## CONSULTEE RESPONSE (Arun District Council - Arboriculturist)

Reference: AL/143/24/RES

Proposal: Approval of reserved matters following outline consent AL/129/21/OUT for 93 No. residential dwellings with associated parking, landscaping, open space (including play areas), infrastructure and works. This application is in CIL Zone 3 and is CIL Liable as new dwellings.

Location: Land adjacent to Woodgate Nurseries, Lidsey Road, Aldingbourne, PO20 3SU

SHEET 2 OF 4

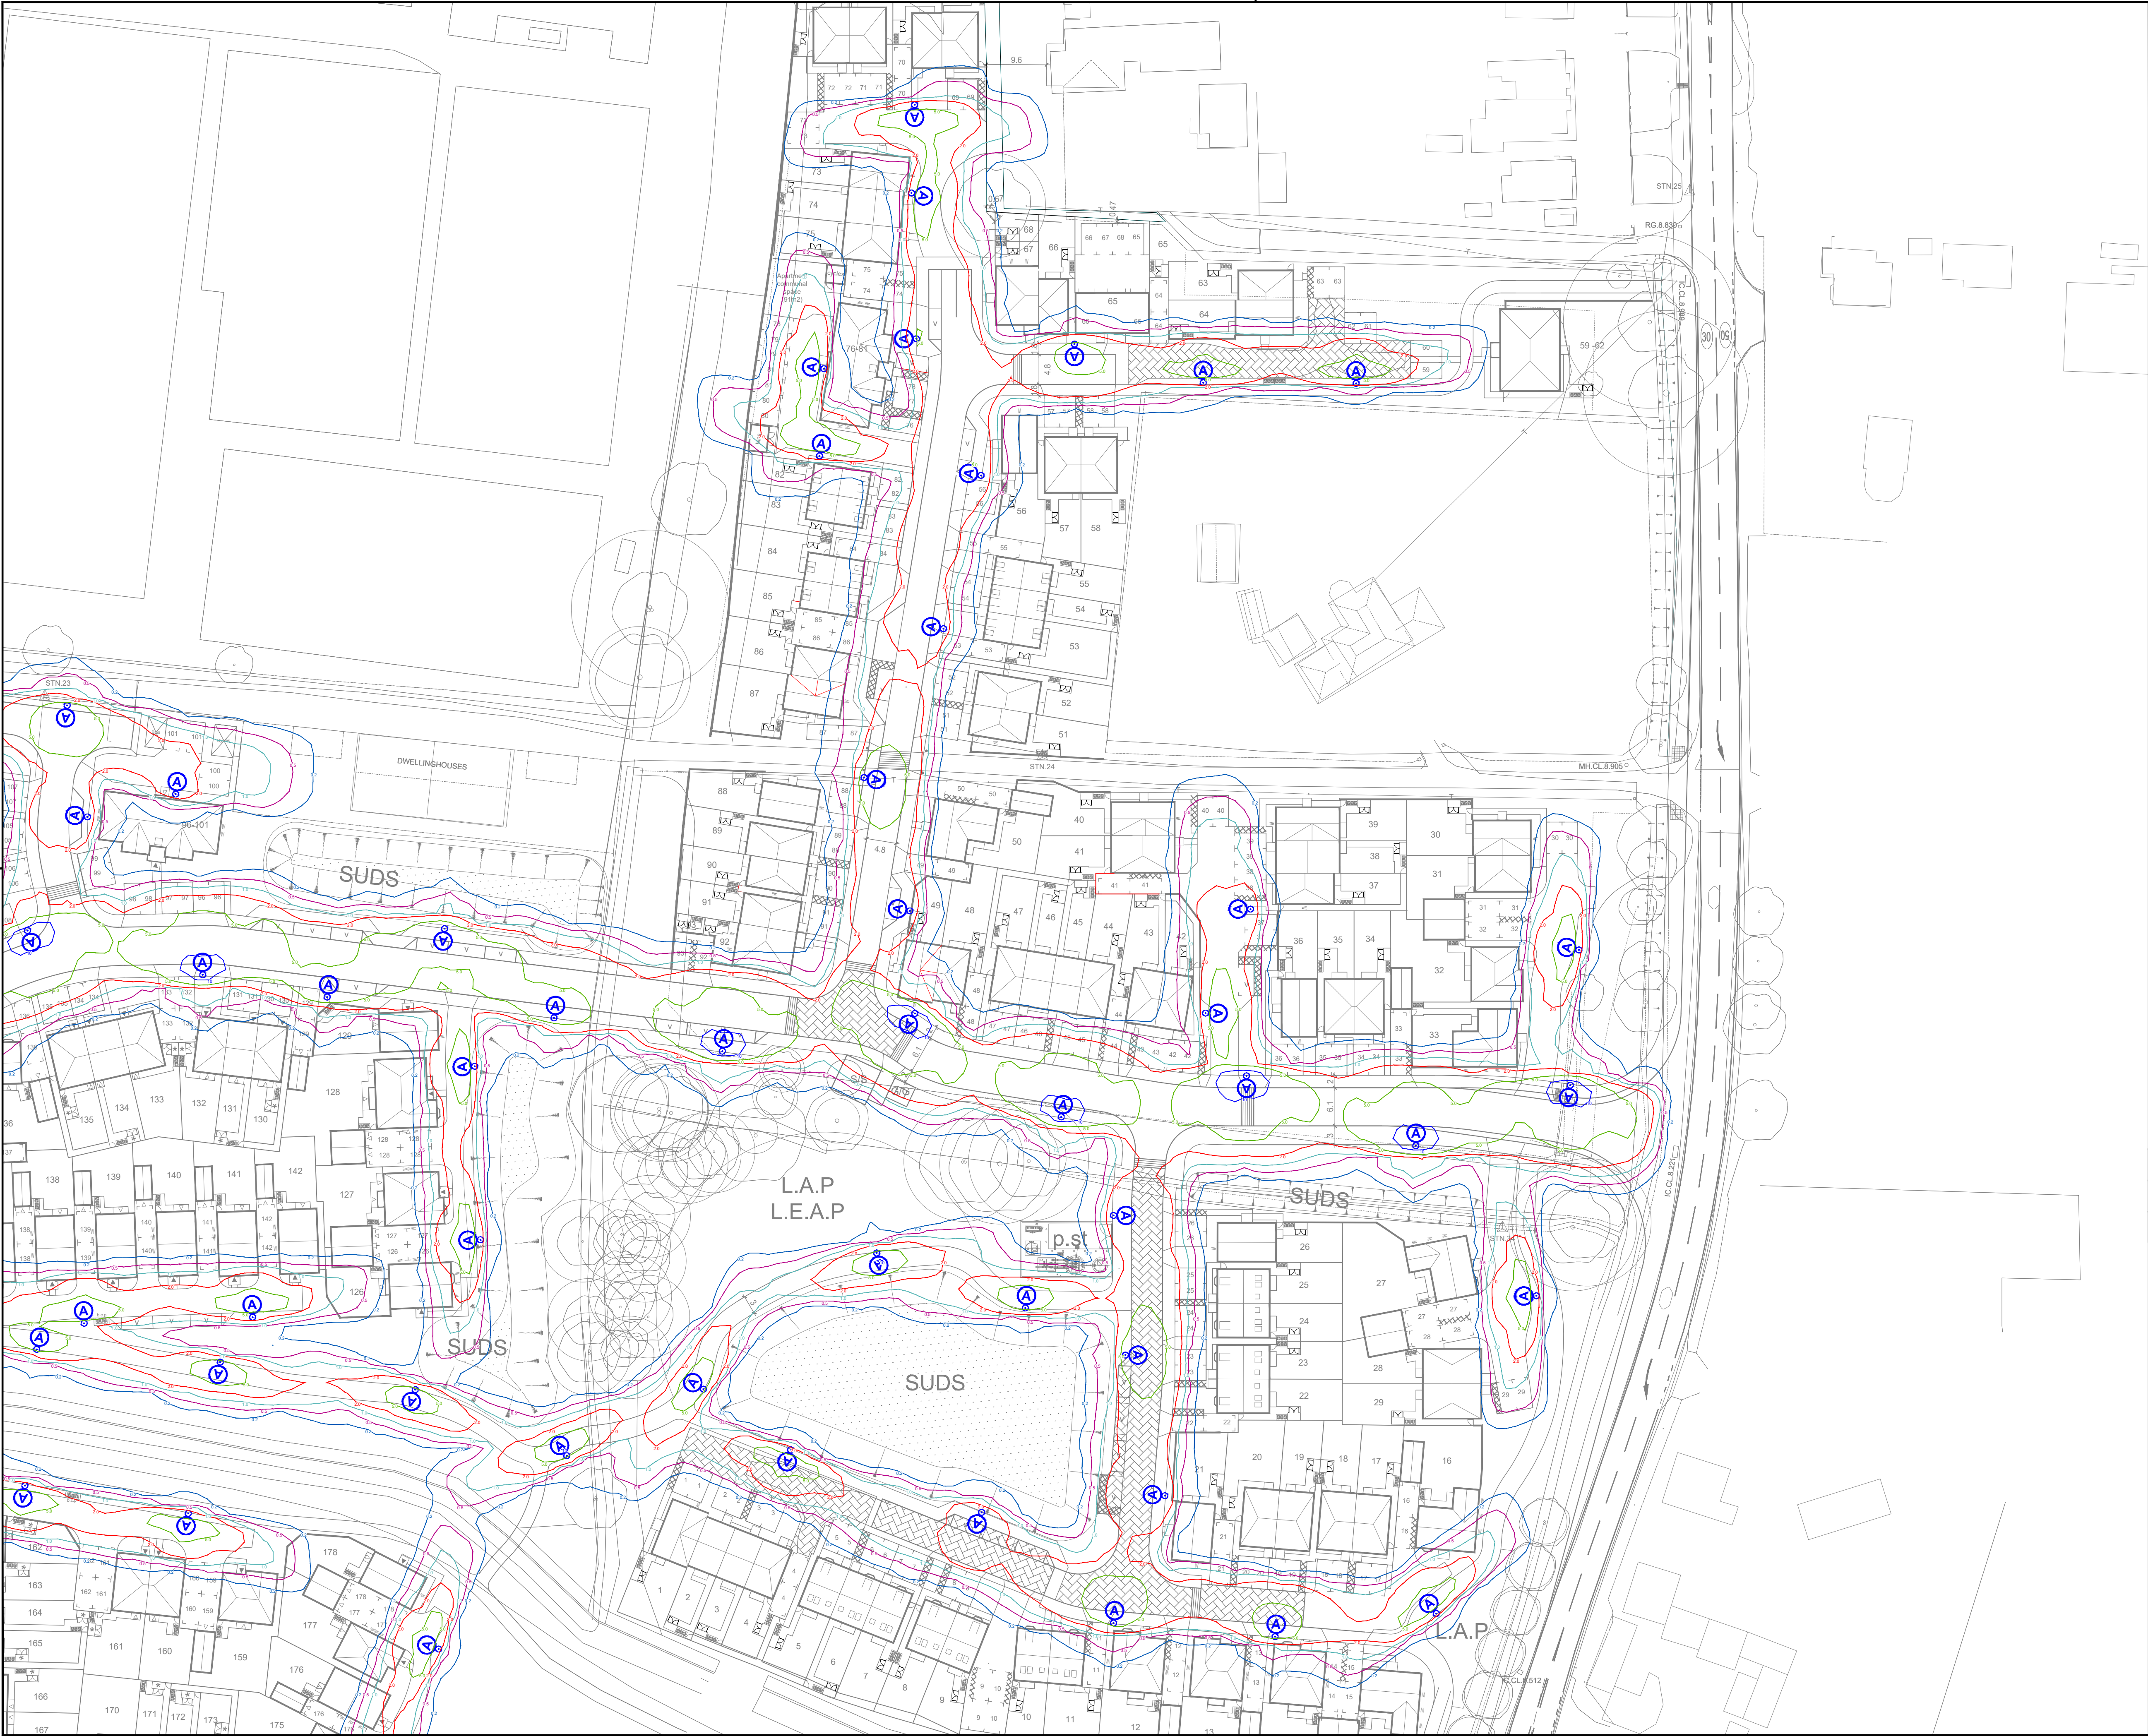
Remaining exposed pair of trees at southern end of clearing. Proposed development within shared RPA includes footway and street lighting. See S278 HIGHWAY IMPROVEMENT WORKS for further potential impacts.
